Our Ref: AW/114/19/HH

**Town & Country Planning Act 1990 (as amended)
Town & country Planning (Development Management Procedure) (England) Order 2015
Application for Planning Permission for Works or Extension to a Dwelling**

Development Two storey side extension and single storey rear extension
Location 20 Tangmere Gardens Aldwick

SITE PLAN - scale 1:500

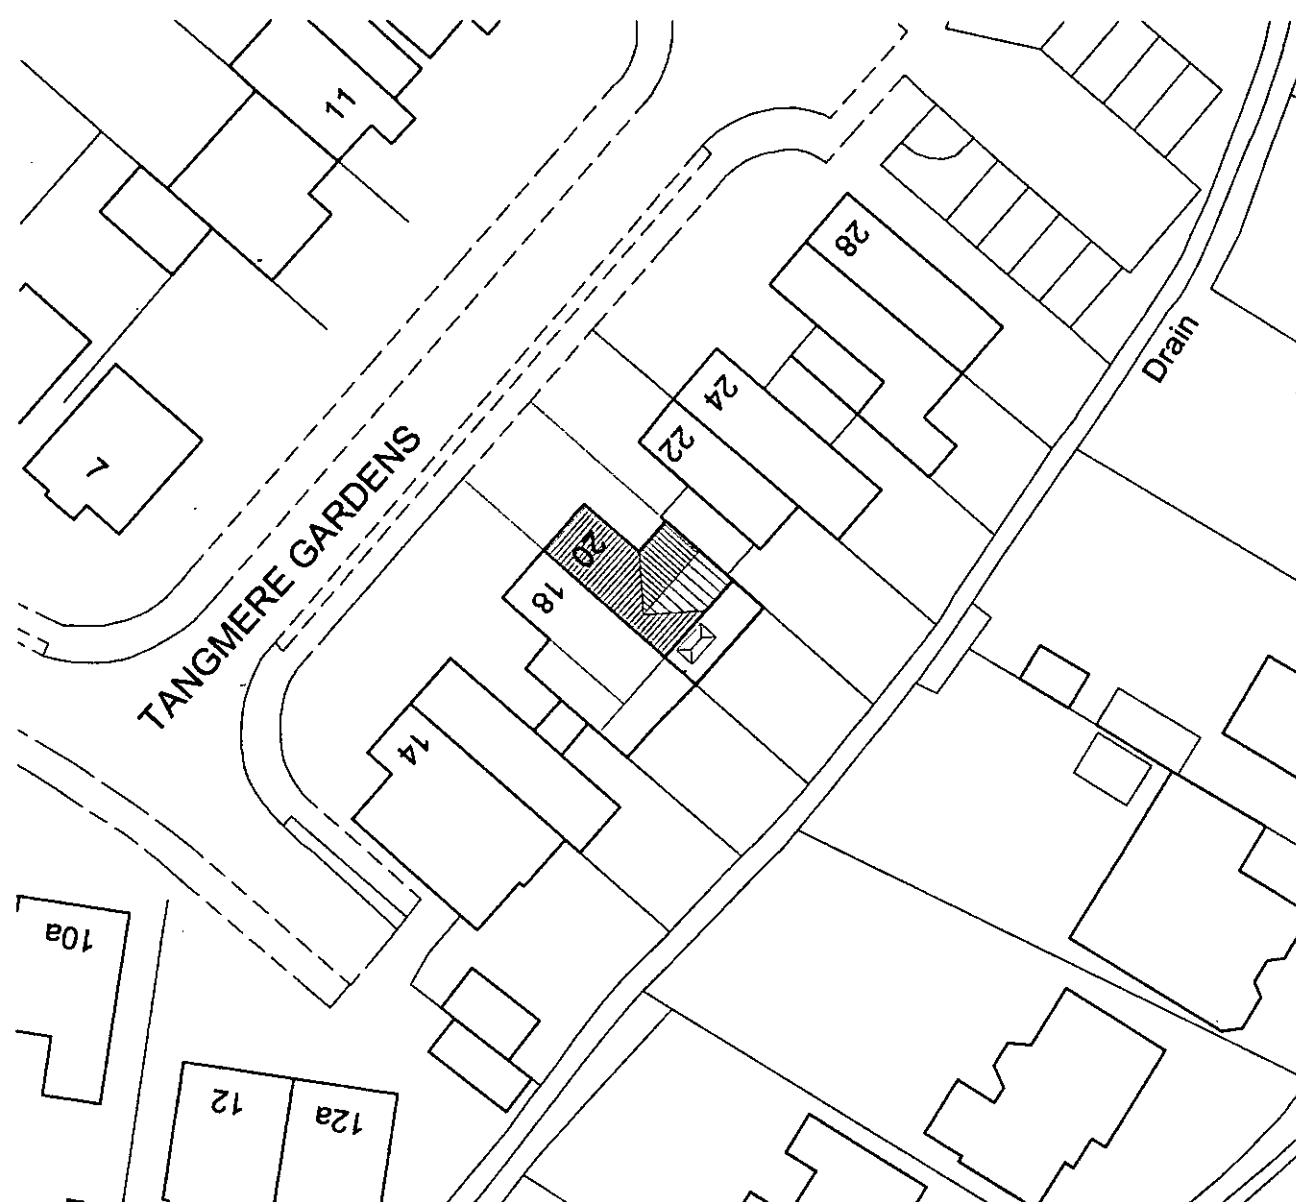
Block Plan

Please submit 1 electronic or 3 paper copies of a block/site plan which includes all dimensions from the proposed extension to the site boundary.
